June 24, 2024

Re: N-Demand Expansion
3810 Academy Parkway NE
30-Day Temporary Certificate of Occupancy
Transportation Development Final Inspection
Engineer's Stamp dated 04-12-22 (E17-D001J)
Certification dated 06-17-24

Based upon the information provided in your submittal received 06-19-24, Transportation Development has no objection to a 30-day Temporary Certificate of Occupancy based. This letter serves as a "green tag" from Transportation Development for a 30-day Temporary Certificate of Occupancy to be issued by the Building and Safety Division.

TRAFFIC CIRCULATION PLAN

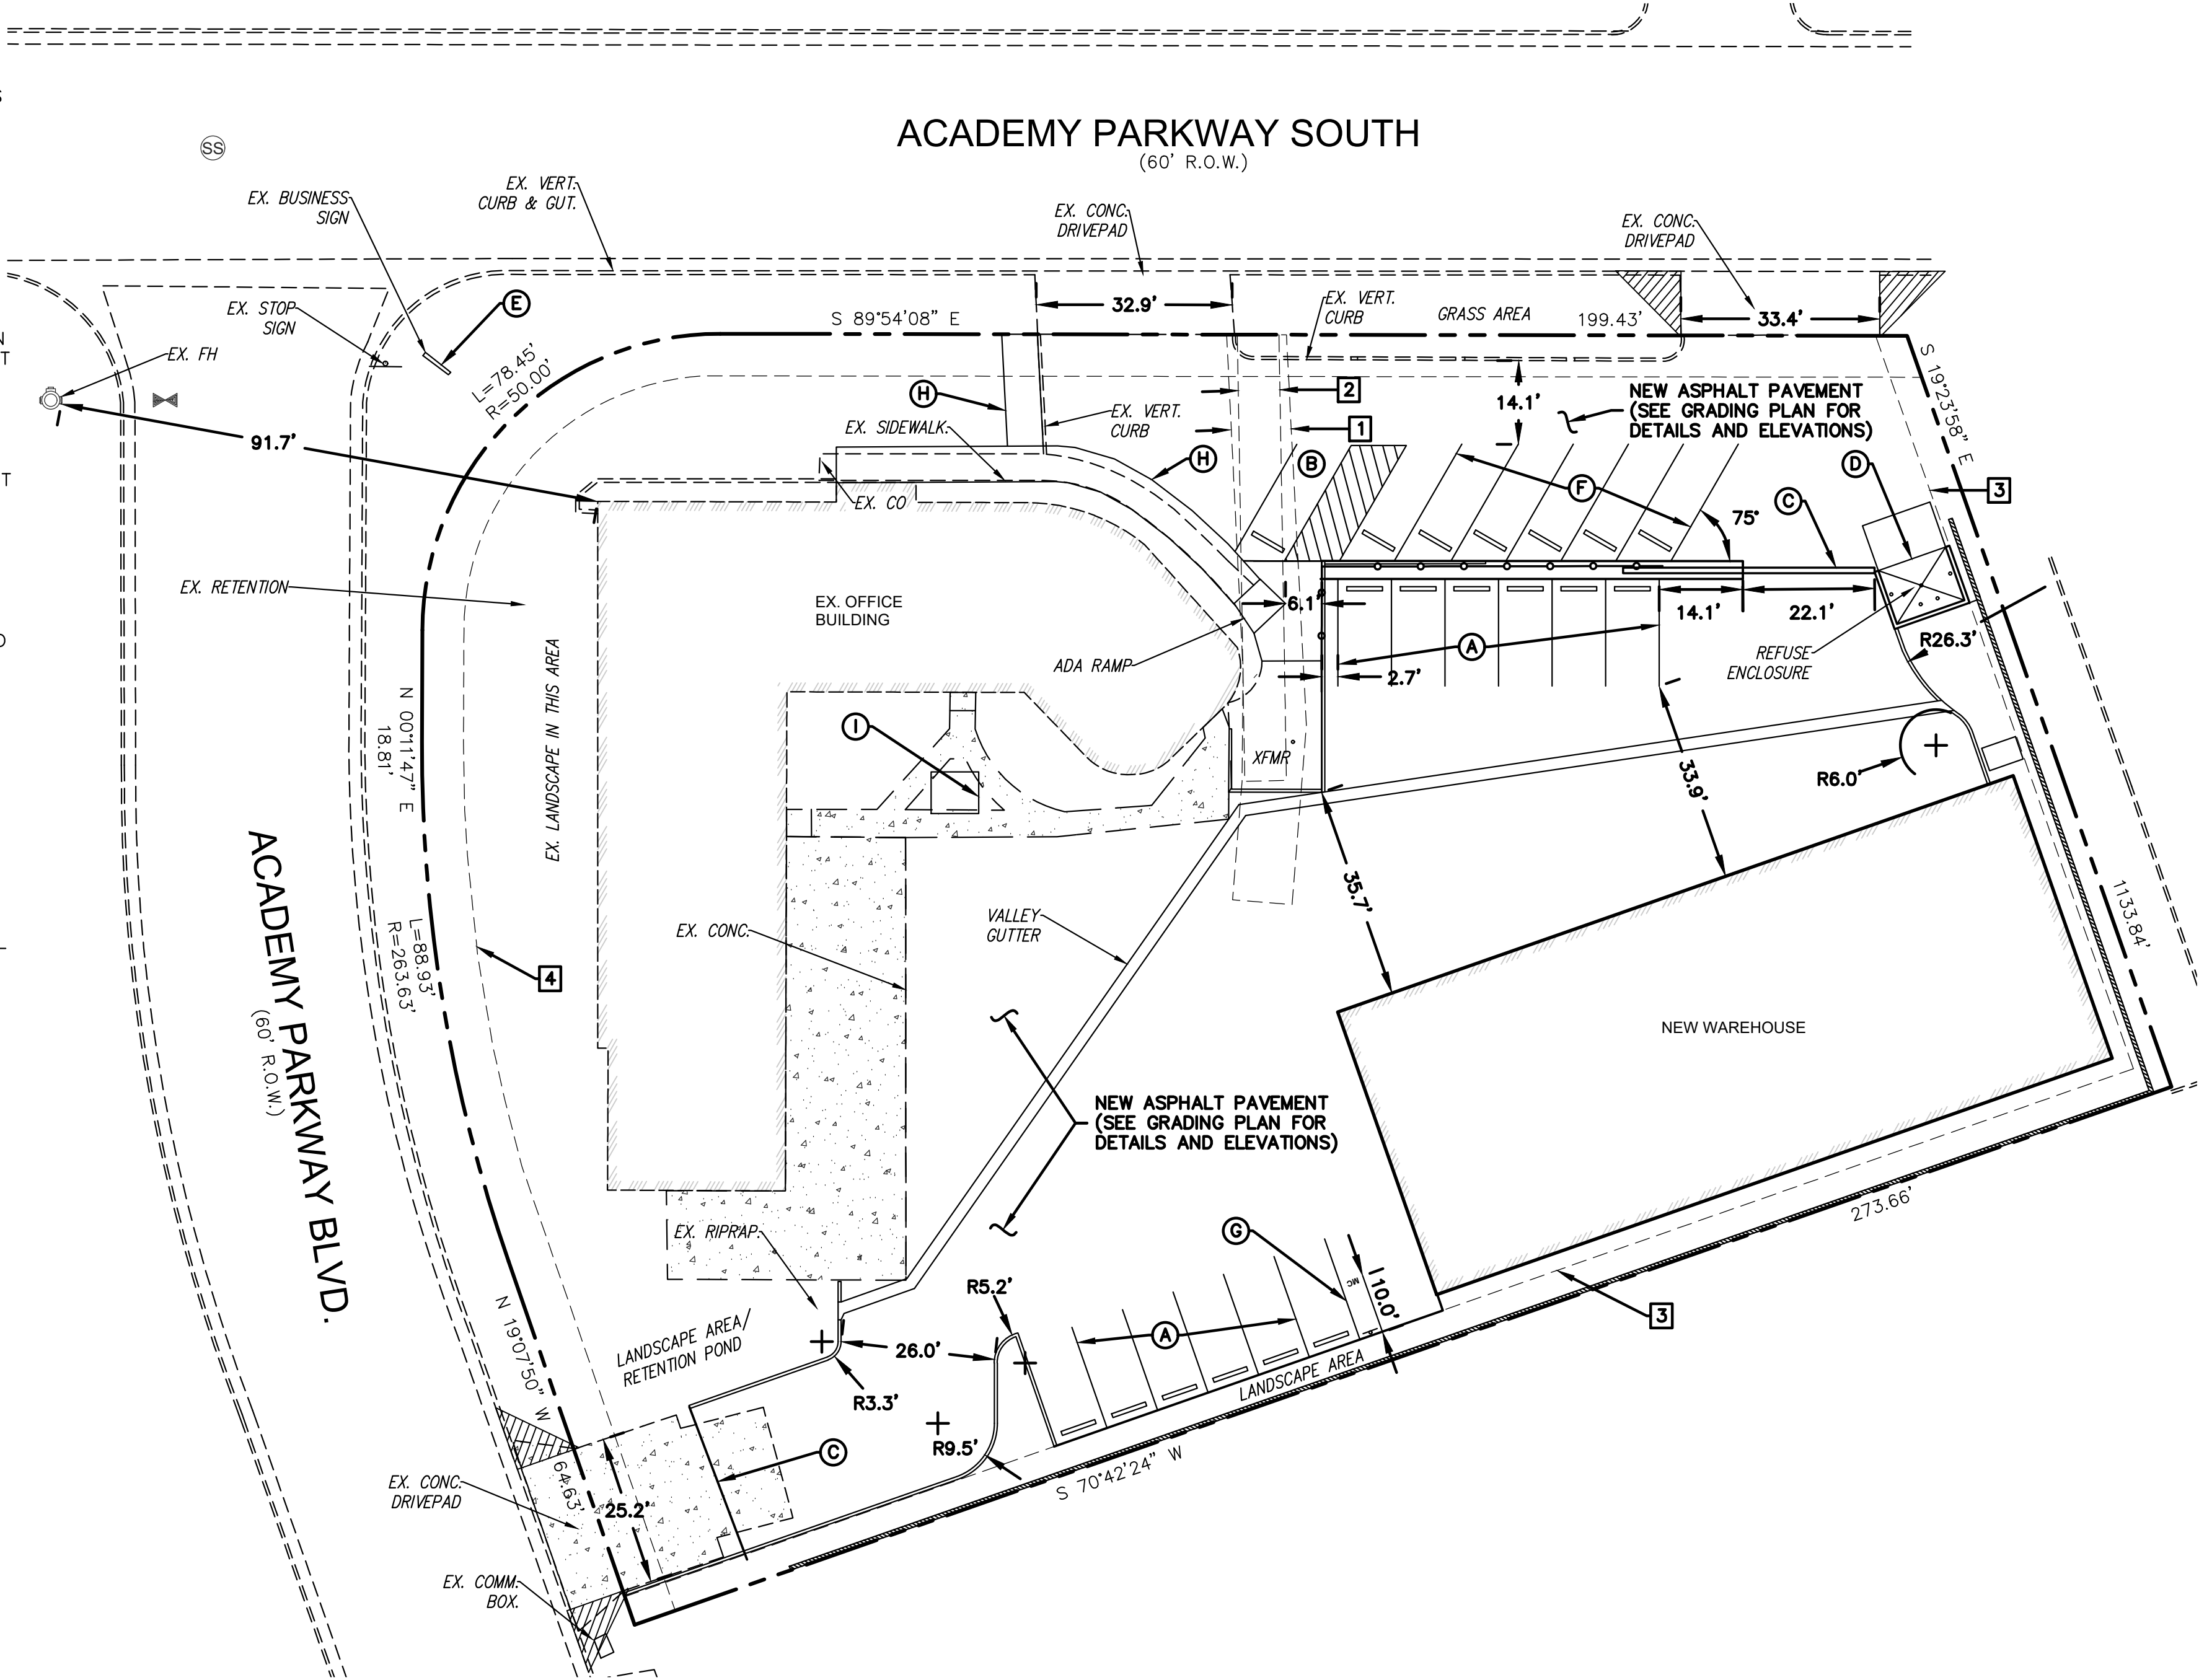
- Keynote H: Per the approved plan, the ADA pathway to building entrance must be constructed.

- Due to closed gate and the un accessible site, please send me picture of the bike rack.
